MRS LESLEY ROWLAND

23 September 2013

I am writing to you objecting to the planning permission of building 3 x 1 Bedroom Flats at the site of 1 Willowbrook, BN17 7NW. Ref LU/104/13/
I am sure I am not the only resident within the area to have written to you about this matter.

Existing and Proposed Rear
Elevations.

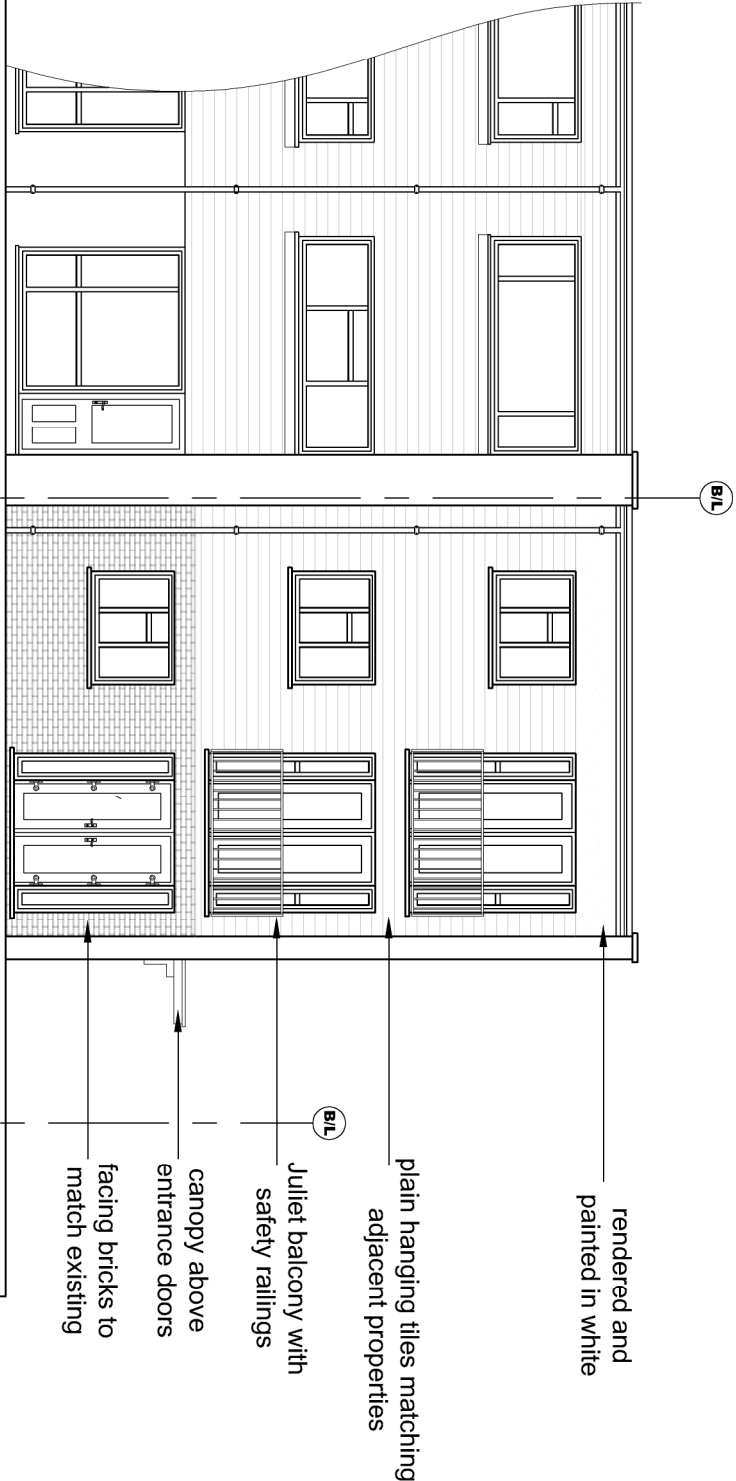
I have also seen from the plans that the back of these flats have been designed with "Juliet" balconies with safety rails, this is not in keeping with any properties around Willowbrook or Stean Furlong.

Proposed Block Plan.

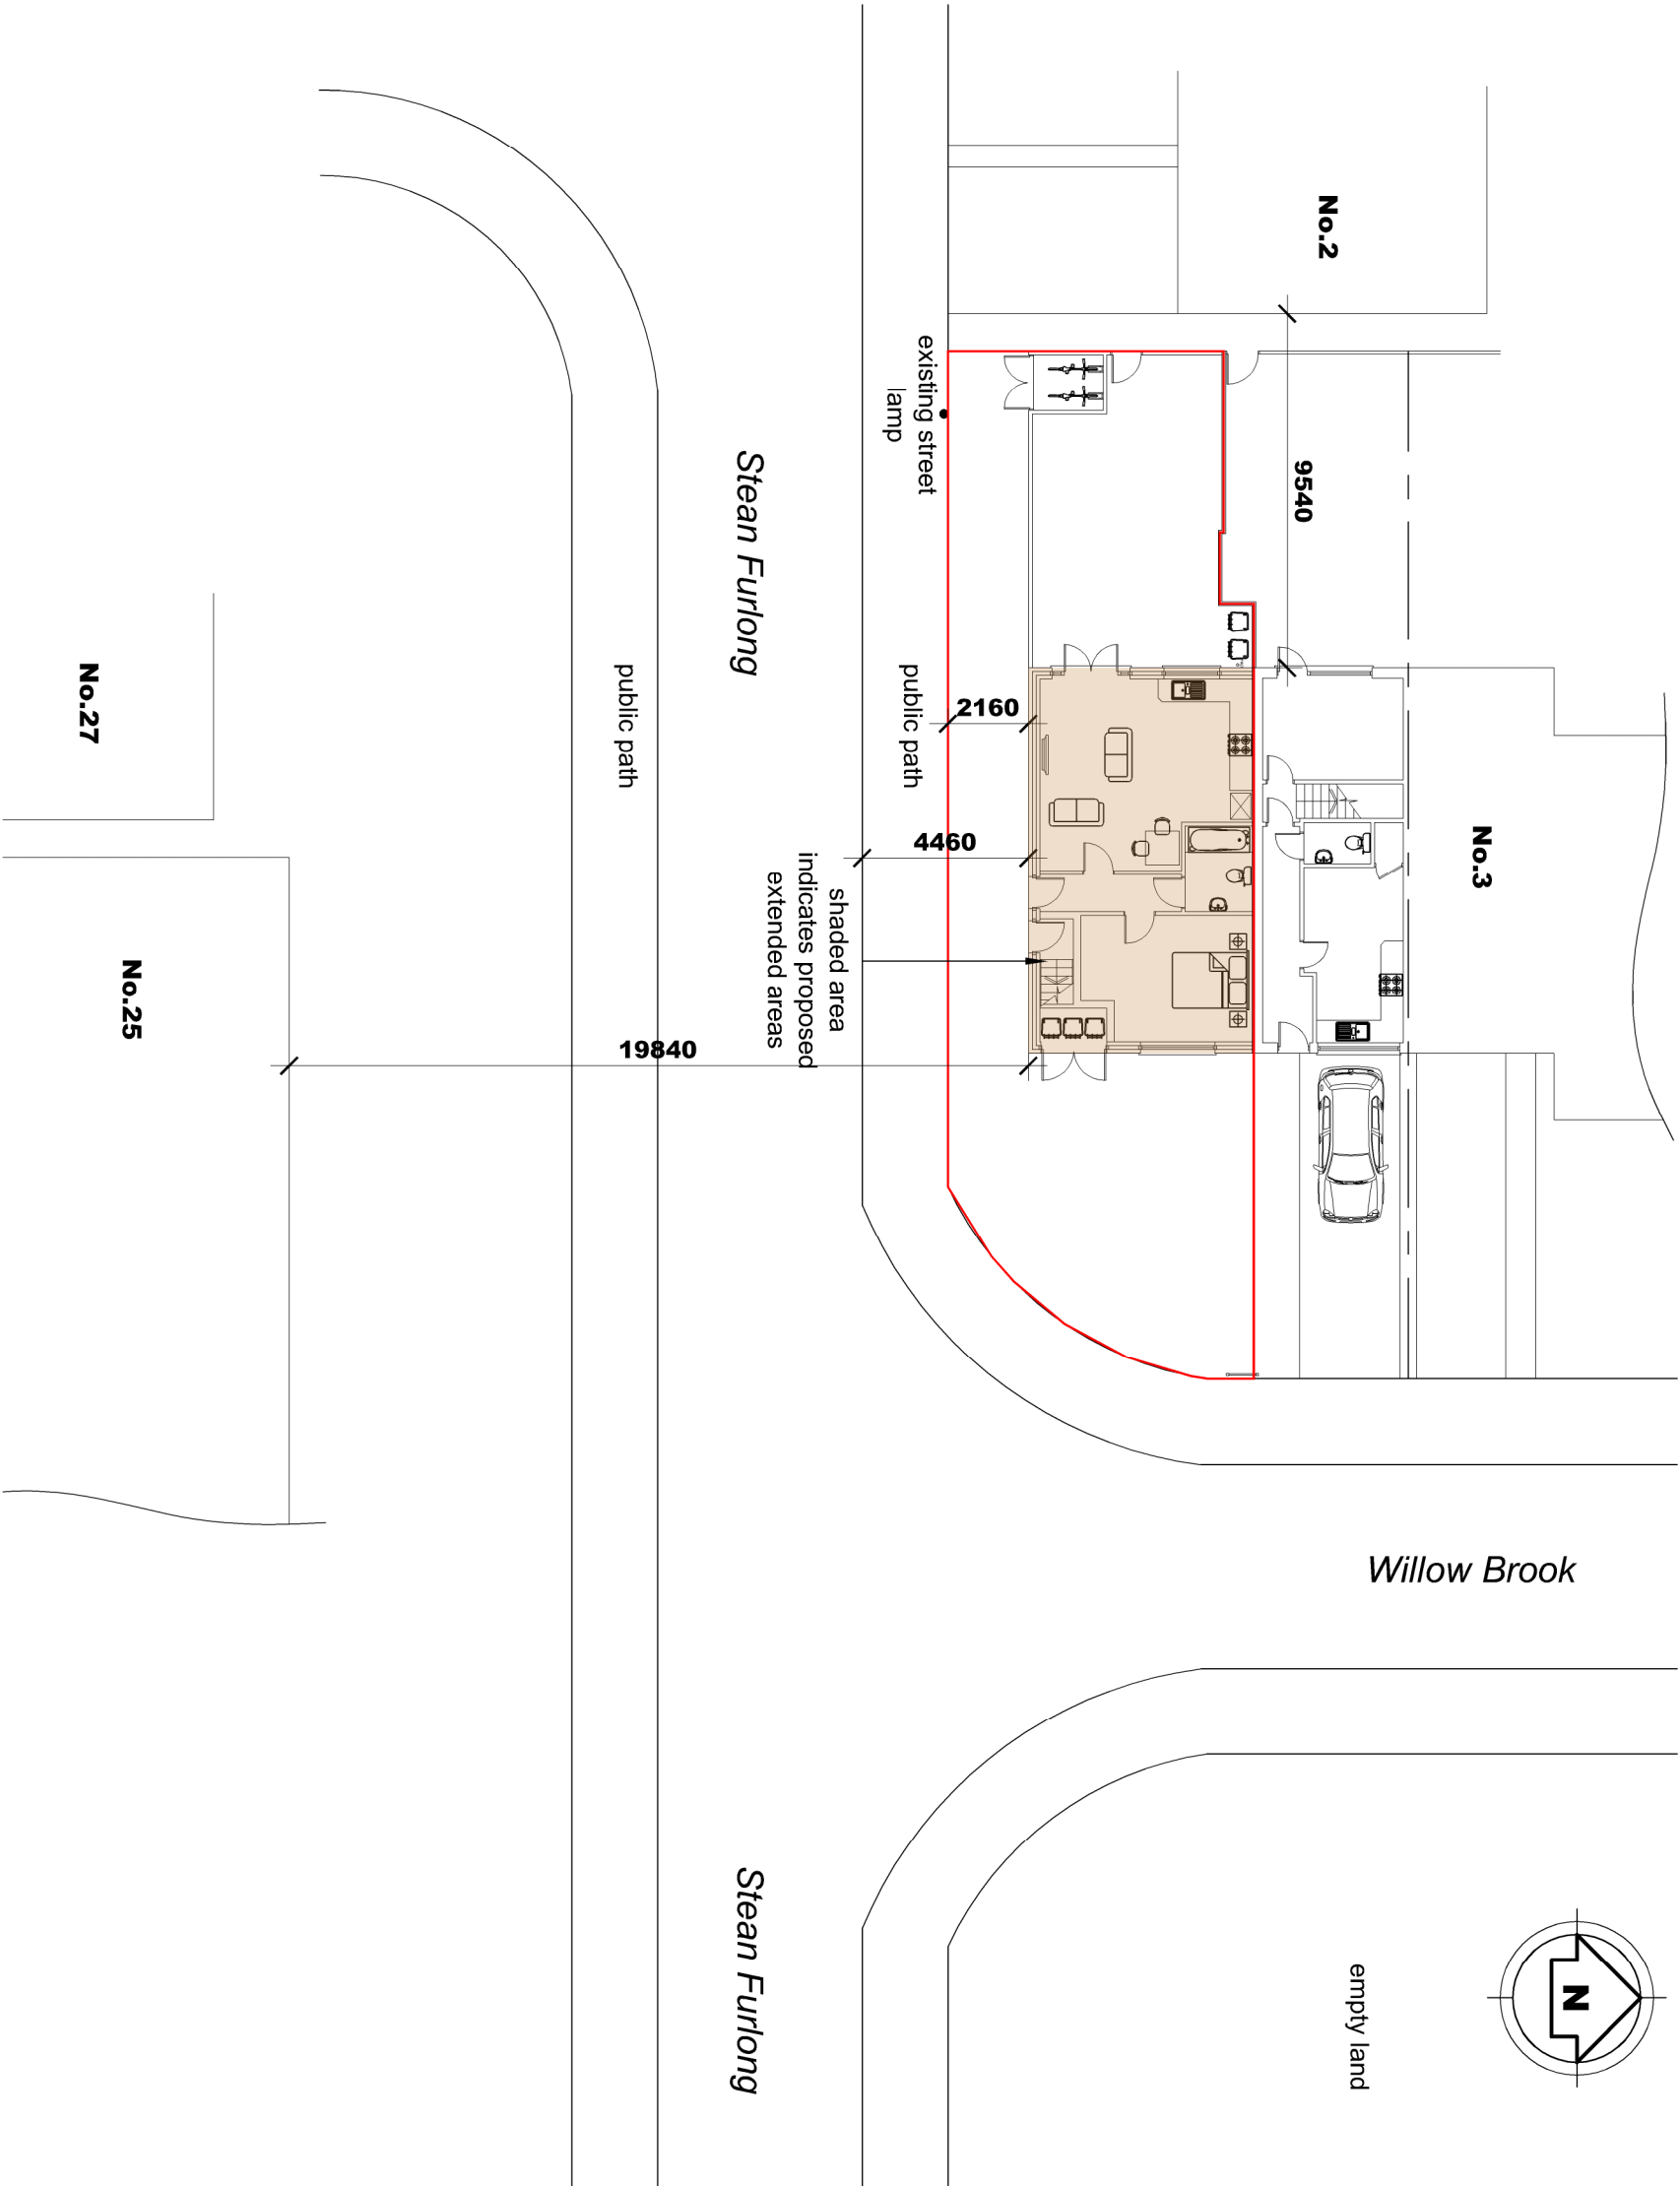
I have also seen from the plans that there is to be no parking facilities for these new properties. Currently it is a free for all, for all those people who already live here who have more than one car, which is most residents. Potentially there could be another 6 cars which will need to park somewhere.

I have also noticed though that there is to be a "cycle storage" area for the upper flats at the end of the garden opening onto the pavement. I am concerned about this as it poses a great threat of being broken into. I feel it will be a constant worry to me especially at night as my bedroom will overlook this area and I live on my own.
